From:	Sean Molloy <smolloy@jodireland.com> on behalf of Sean Molloy</smolloy@jodireland.com>
Sent:	Tuesday, January 26, 2021 12:15 PM
То:	Ann Kilmartin
Subject:	RE: 6225 GWF & 6226 IWF - Pre-Planning Mtg. with Cork County Council - Scoping
	Opinion
Attachments:	Scoping Report Inchamore wind farm.docx; scoping report for gortyrahilly wind farm.docx; PPW 6225 Gortyrahilly WF & PPW 6226 Inchamore WF EO Advices FV.docx

Scoping opinion on proposed Inchamore Wind Farm, Coolea.

# PPW: 6225 Gortyrahilly Wind Farm, Co. Cork and PPW: 6226 Inchamore Wind Farm, Co. Cork

Re: Request for Scoping Opinion on information to be included in the preparation of an Environmental Impact Assessment (EIA) for Inchamore Wind Farm, Coolea, County Cork

**Figure NTS-3: Viewpoint Map**

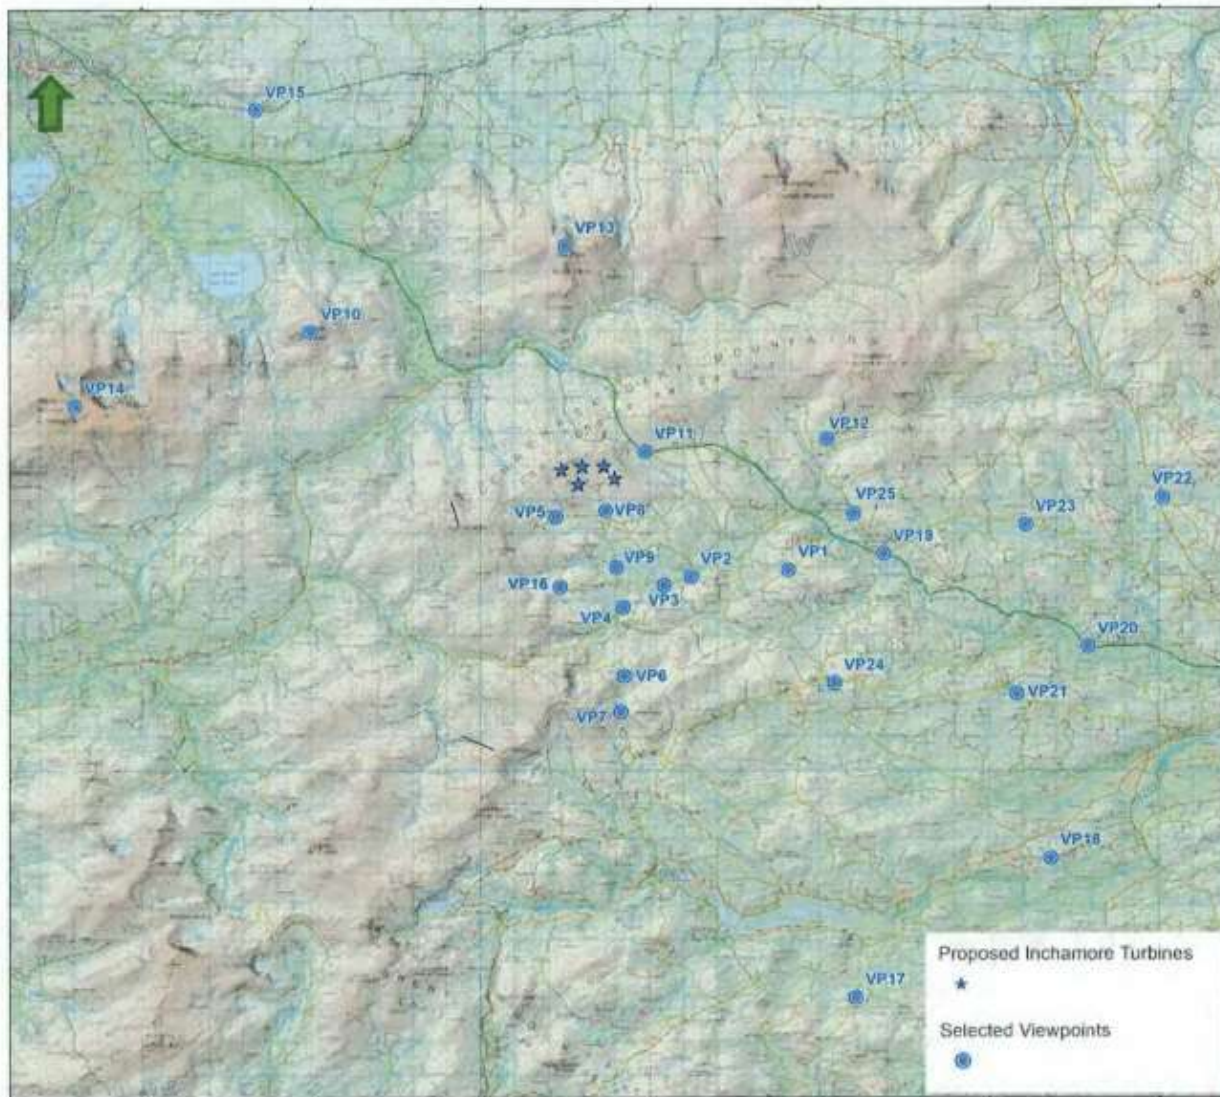
- I refer you to CDP objective HE 2- 3 Biodiversity outside protected areas and the Heritage Chapter as a whole
- Would be useful to add rationale for view point locations, some new viewing points from the new N22 would be of value

- Consider transboundary effects given proximity to Kerry Border.
- Might be worthwhile including some vantage points from new Macroom bypass route in terms of potential visual impacts.

Drw. By	SM	Drw No	-
Checked By	SM	Rev	9
Stage	EIAR	Date	23/05/23
Scale	1:25,000 (A3)	Figure	3.1

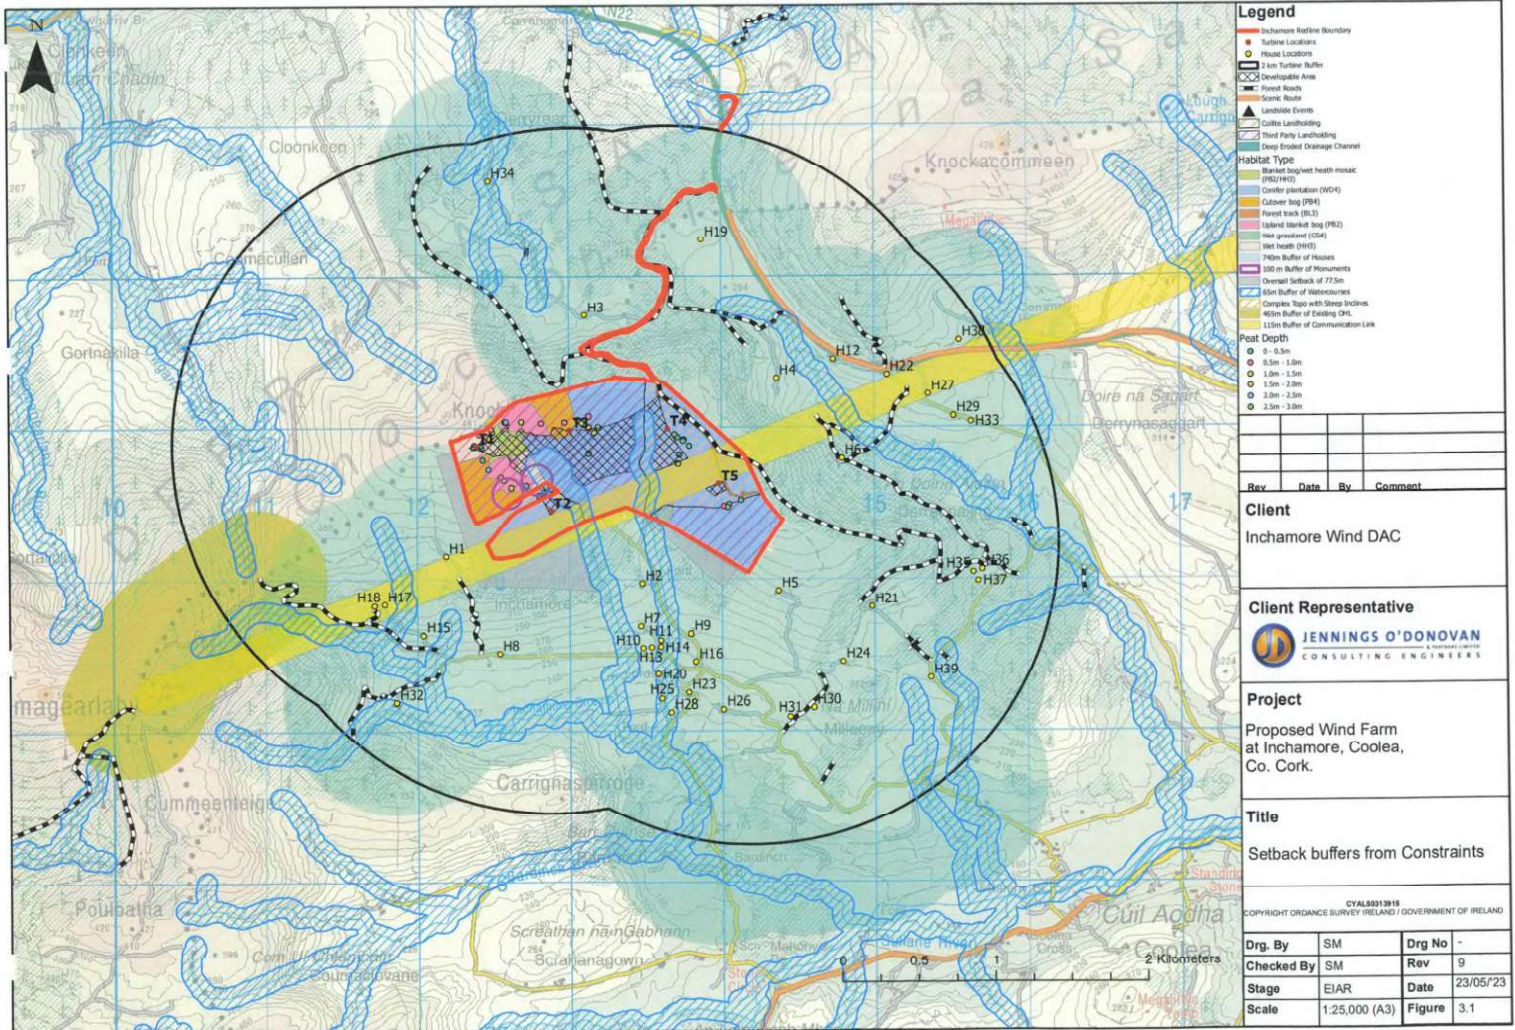
- 'largely intact upland blanket bog' and 'cutaway blanket bog with intact areas' located in proximity to turbine 3 and associated developable areas within the vicinity of these habitats; and
- areas comprising of a 'Mosaic of Upland Blanket Bog and Wet Heath' in proximity to the developable area associated with turbine 1.

- 'largely intact upland blanket bog' and 'cutaway blanket bog with intact areas' located in proximity to turbine 3 and associated developable areas within the vicinity of these habitats; and
- areas comprising of a 'Mosaic of Upland Blanket Bog and Wet Heath' in proximity to the developable area associated with turbine 1.
- Ecological Scoping document acceptable in principle
